| Application No. | 2021/94280 |
| Proposed Development: | Erection of 67 dwellings with associated works |
| Location: | land at, Lady Ann Road, Soothill, Batley, WF17 0PY |

**Consultation Response from KC,
 Trees**
2021/94280 land at, Lady Ann Road, Soothill, Batley, WF17 0PY
Erection of 67 dwellings with associated works
Date Responded: 13/01/22
**Responding Officer: Nick
 Goddard**
Responding Ref: TPO 72/91

1. Precedent planting
2. Native hedgerow
3. Wild flower meadow
4. Path with planting
5. & 6. Community orchard
7. Wild grasses
8. & 9. Street trees and front gardens

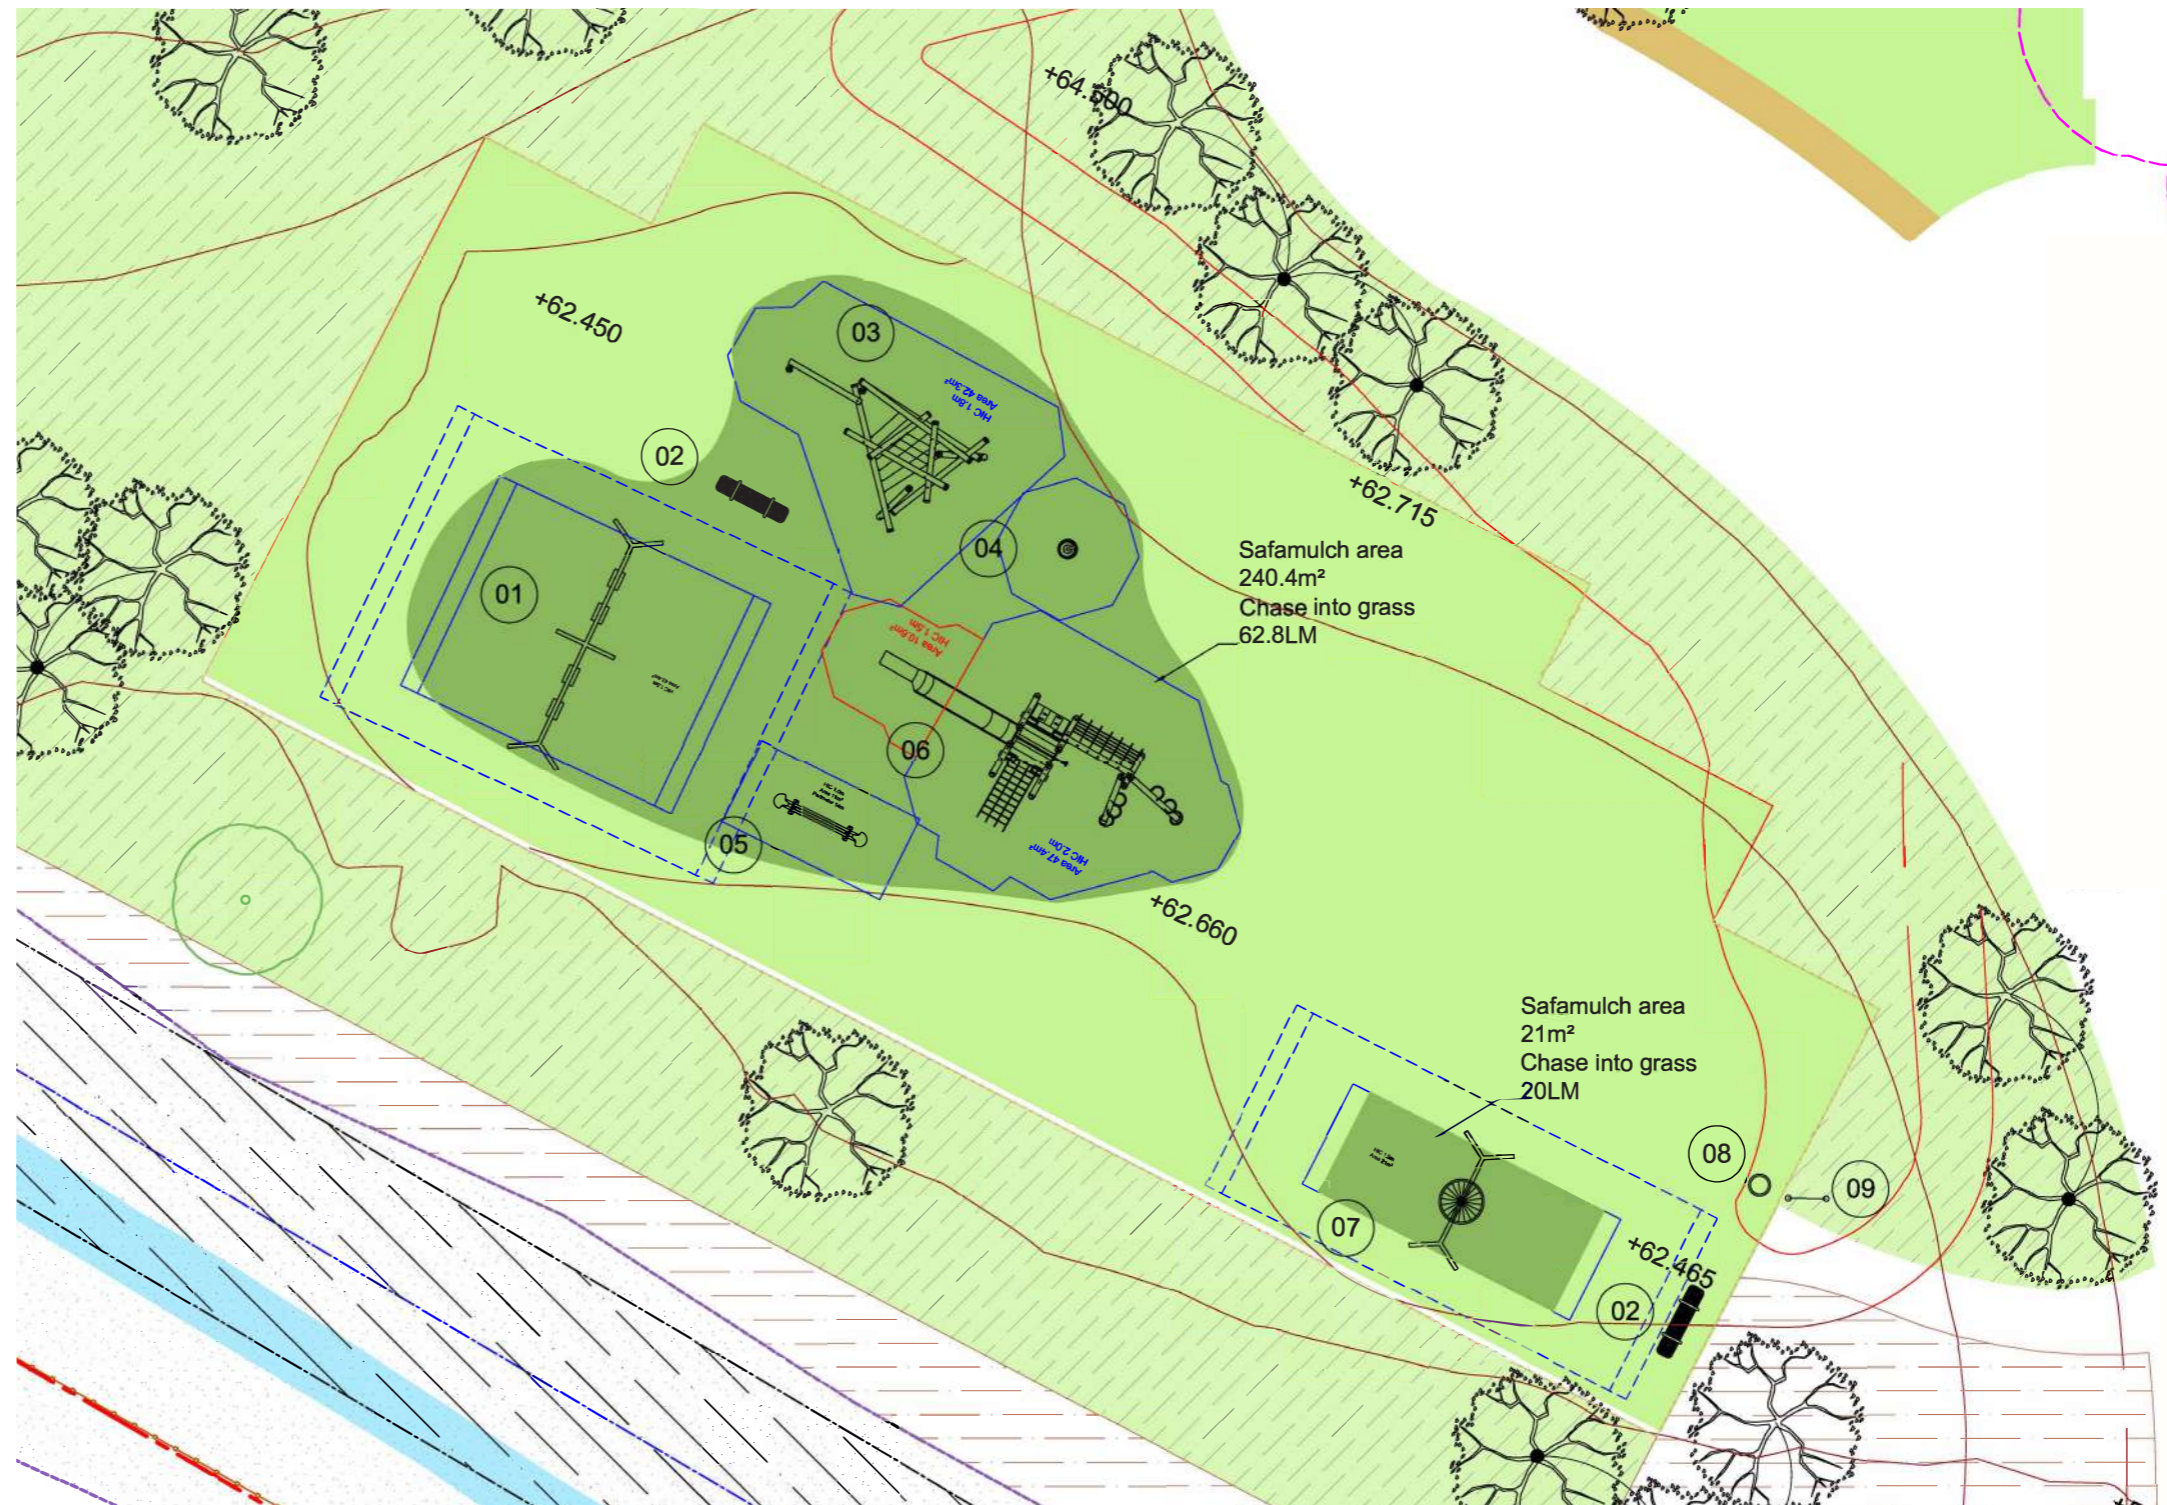
The Landscaping Proposals, drawing 2 of 3, shows the land beneath the protected trees to be wildflower meadow which is a good choice however it mentions the land as being a regarded embankment. The Drainage Feasibility Layout shows the protected trees as removed and dwellings in their place, which is clearly an oversight.
